THE SIZEWELL C PROJECT
NNB Generation Co (SZC) Ltd

EN010012

SUMMARY OF WRITTEN REPRESENTATION and
EXPERT REPORT

A critical review of SZC Co's site characterisation, impact assessment, and proposals for impact mitigation, in relation to the risks posed to the ecohydrological integrity of Sizewell Marshes SSSI

**DRAWING TITLE:**  
SIMULATED STAGE AT STREAM GAUGING LOCATIONS (INCREASED PERMEABILITY CUT-OFF WALL 2015-2040)

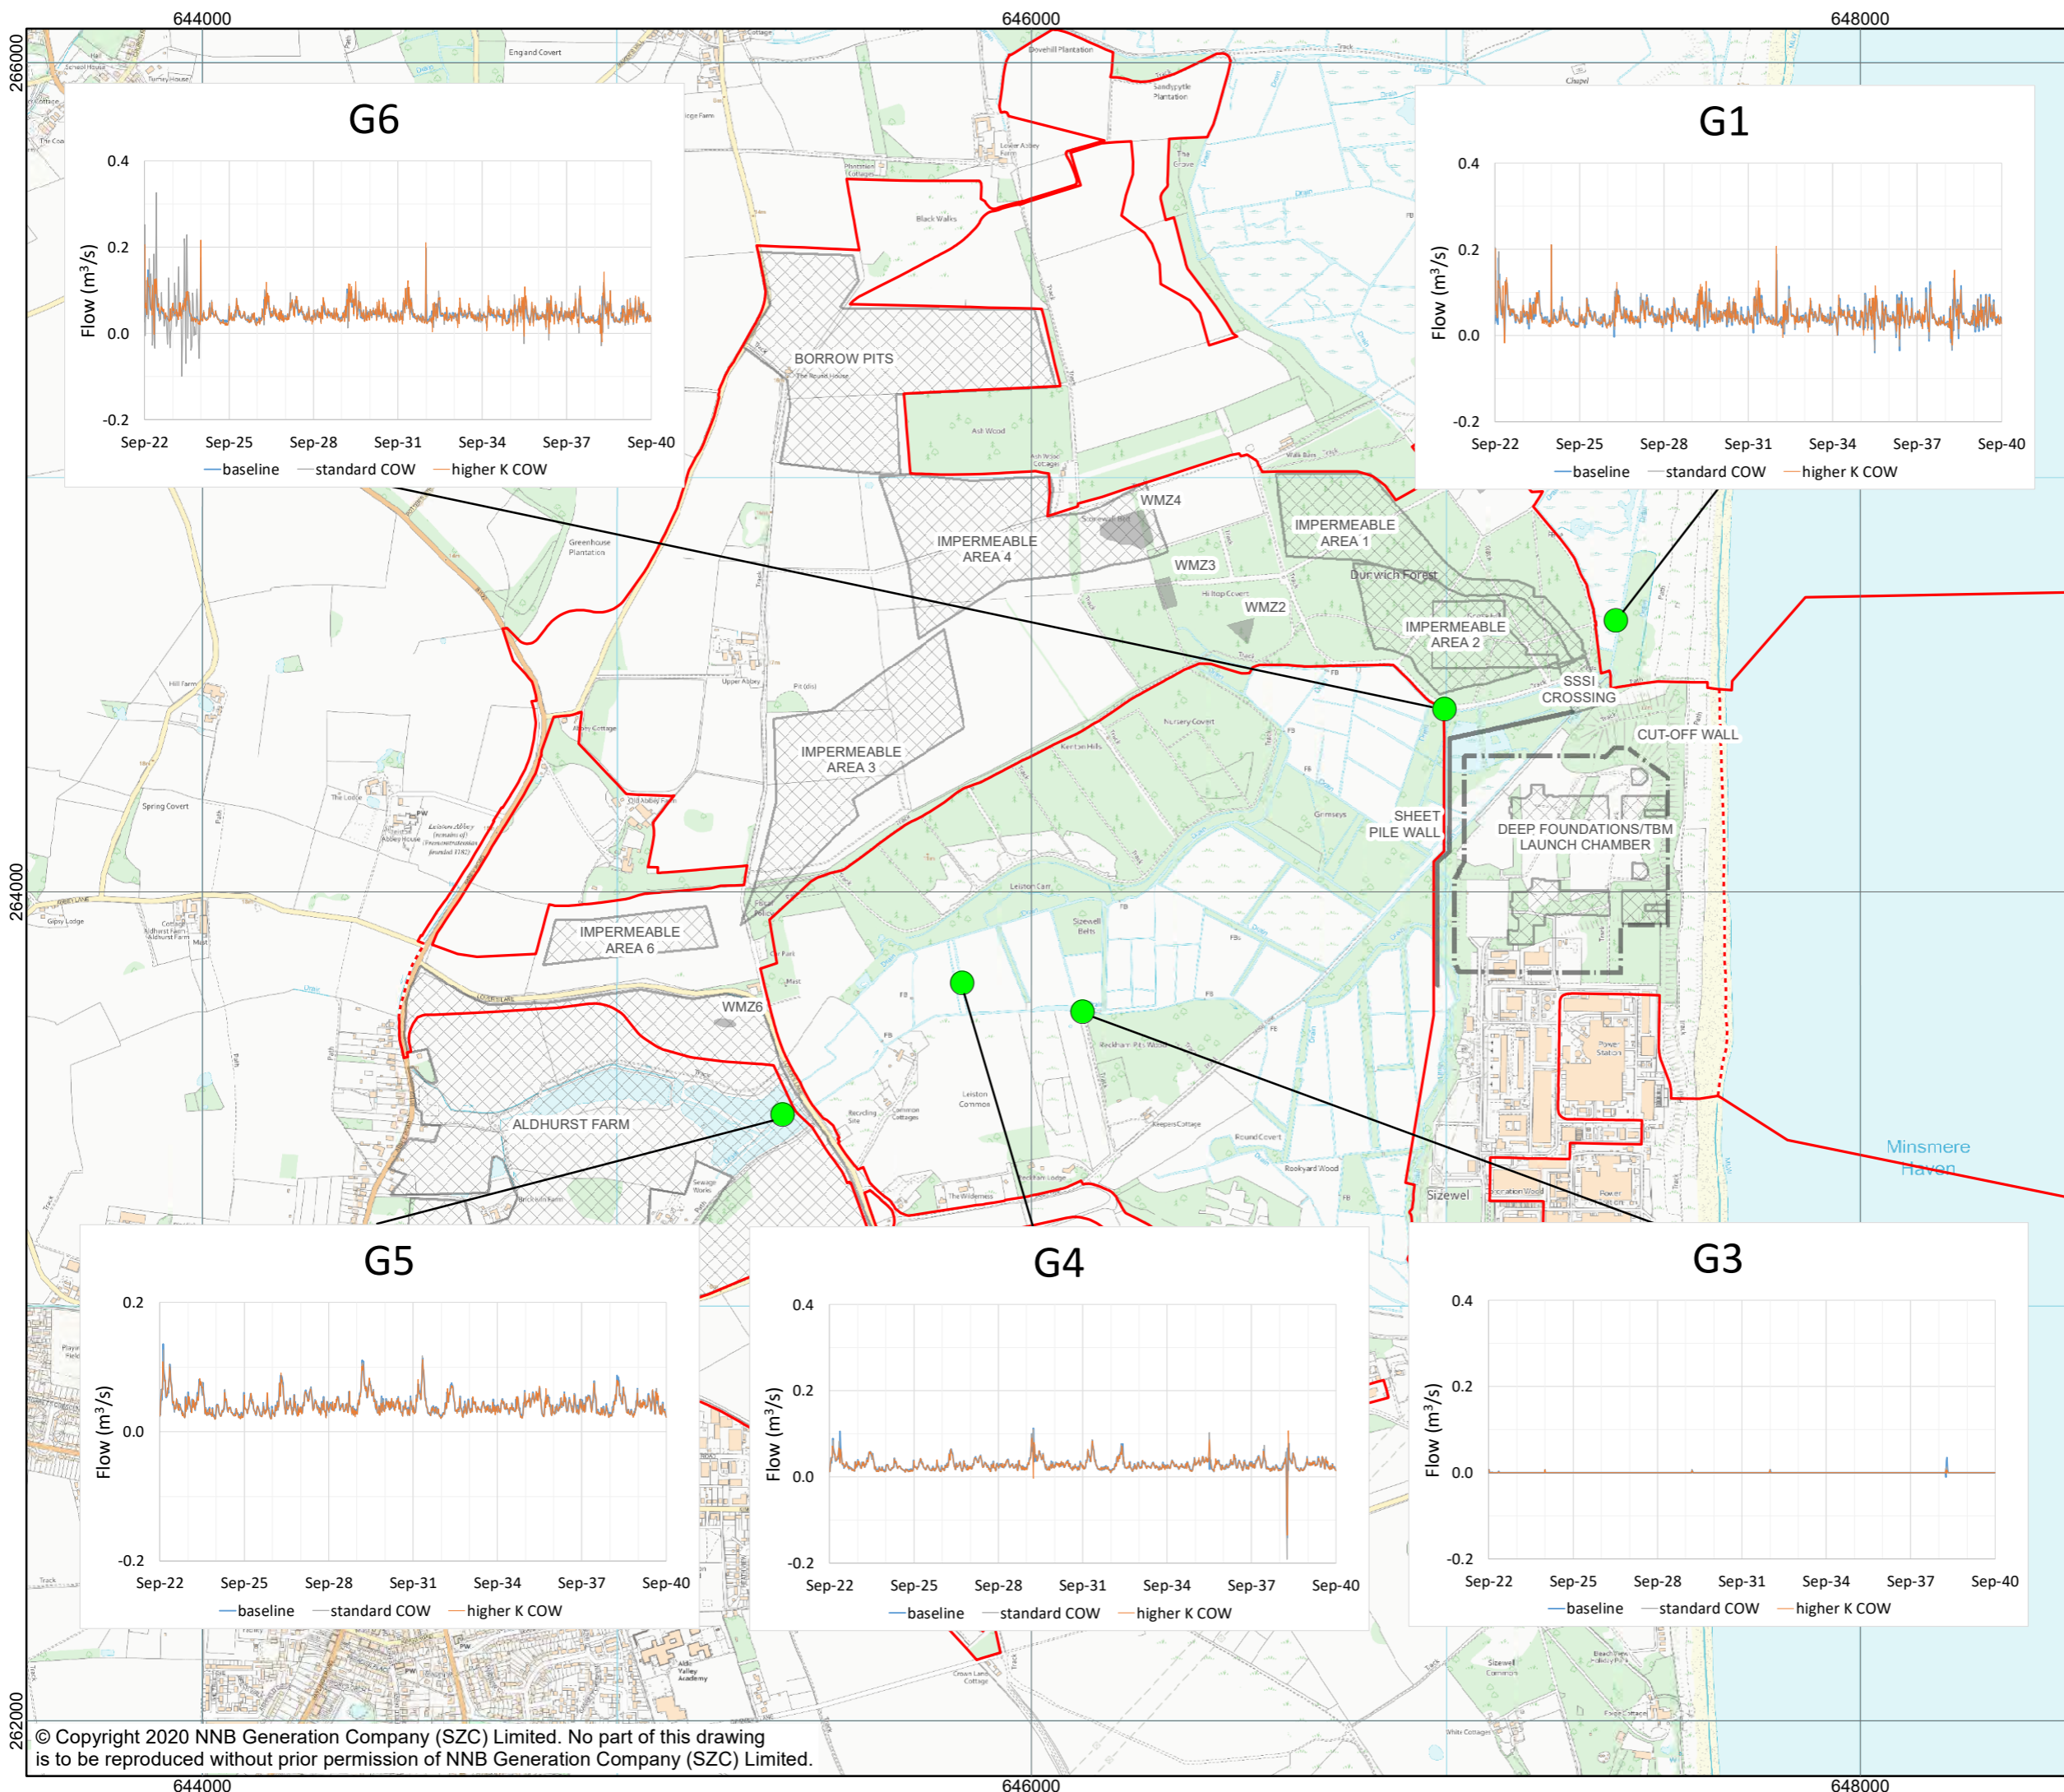
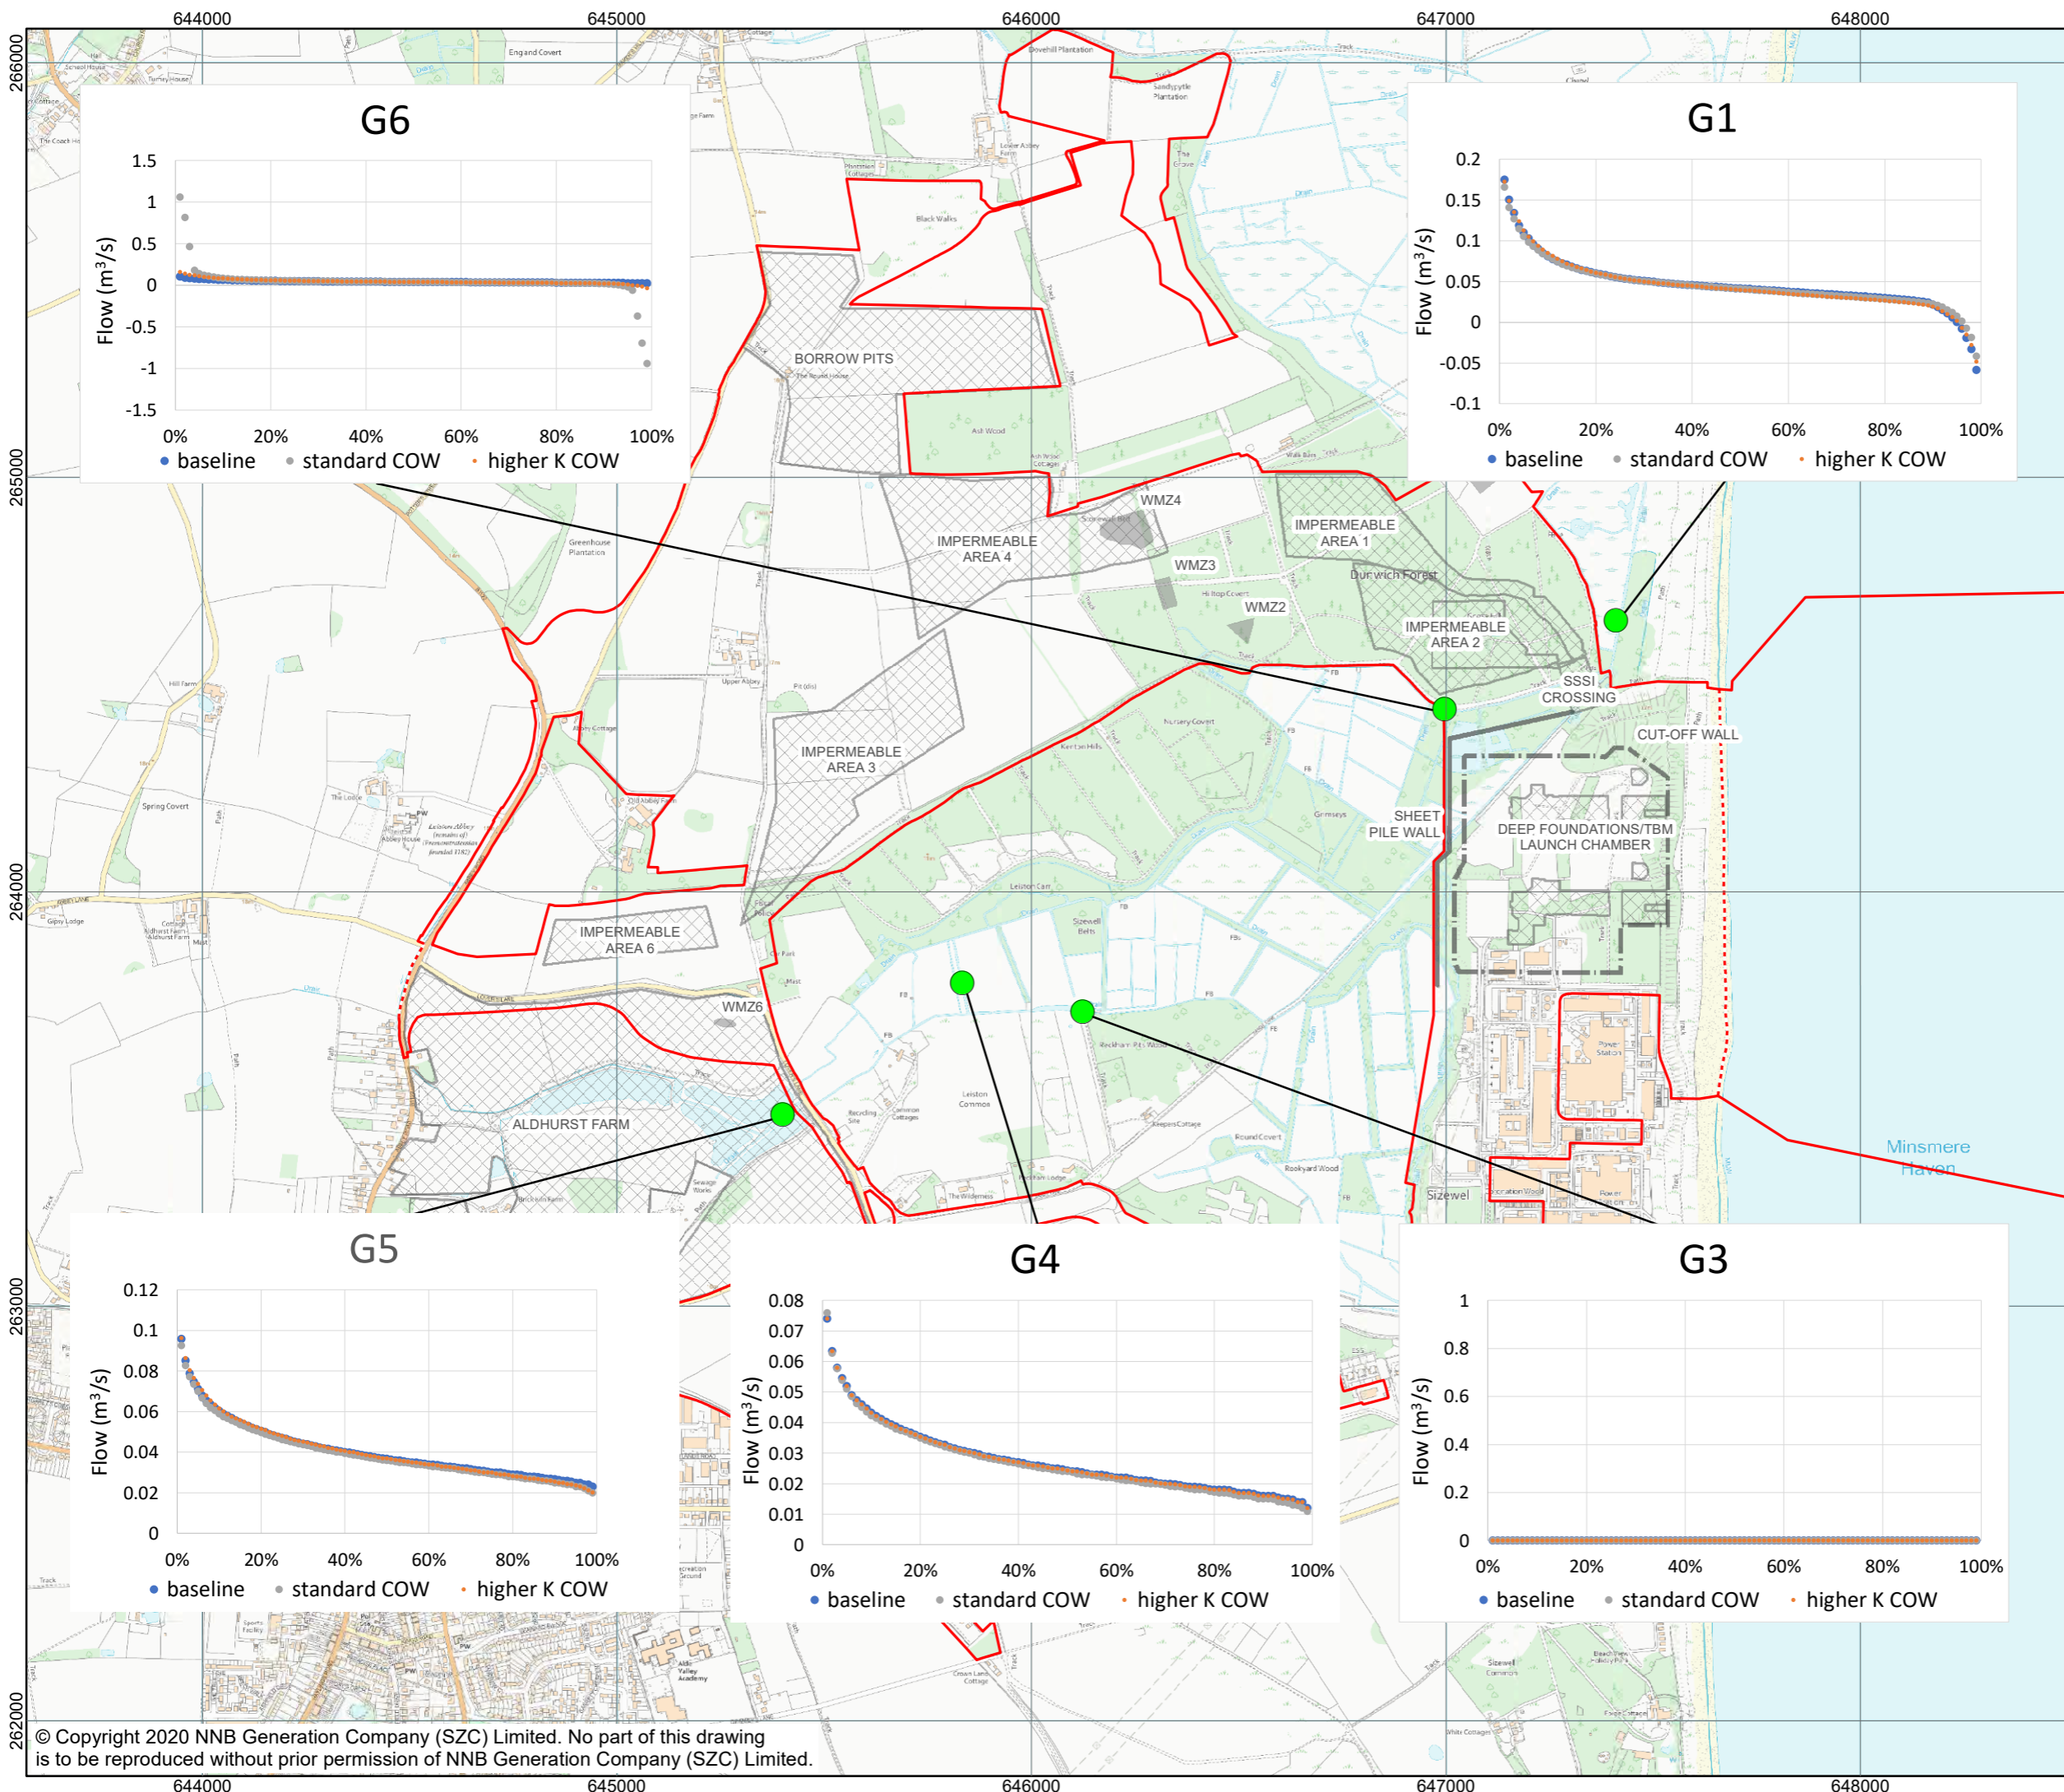
- The design of the model sensitivity analyses is overly optimistic; the effects of a three- to five-fold increase in the hydraulic conductivity of the cut-off wall should have been tested, and some (not unlikely) combinations of single sensitivity analysis scenarios should have been tested. If this had been done, it would have shown that there is a reasonable chance that projected drawdowns will be significantly larger than the base-case model, and in turn that the M22 community is potentially significantly more vulnerable to the proposed development.
